Reviewed for Code Compliance
 Permitting and Inspections Department
 Approved with Conditions

WAGLEOD
 275 Park Street, 3rd
 Portland, ME 04103
 SECOND FLOOR ADDITION
 11/21/2018

- THIS PROJECT CONSISTS OF -
1. ADDING A SECOND FLOOR IN-LAW APARTMENT OVER THE EXISTING GARAGE AND KITCHEN/ LIVING ROOM OF THE HOUSE.
- THE FOOTPRINT OF THE BUILDING IS UNCHANGED
- EXISTING COMPONENTS TO REMAIN EXCEPT AS NOTED HEREIN

SECOND FLOOR ADDITION
21 STUART STREET
PORTLAND, MAINE

**PROPOSED SECOND FLOOR PLAN**  
SCALE: 1/4" = 1'-0"

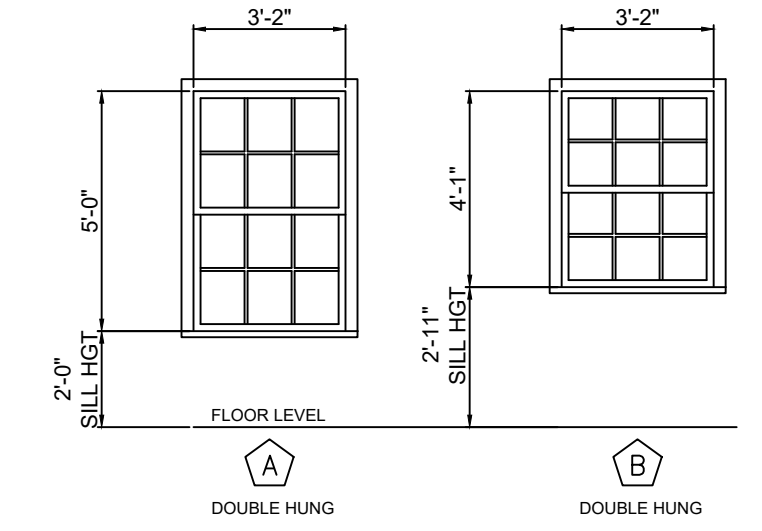
The addition of the new dwelling unit requires that the entire building be sprinkled. Please note on the drawing that an NFPA-13D system will be installed throughout.
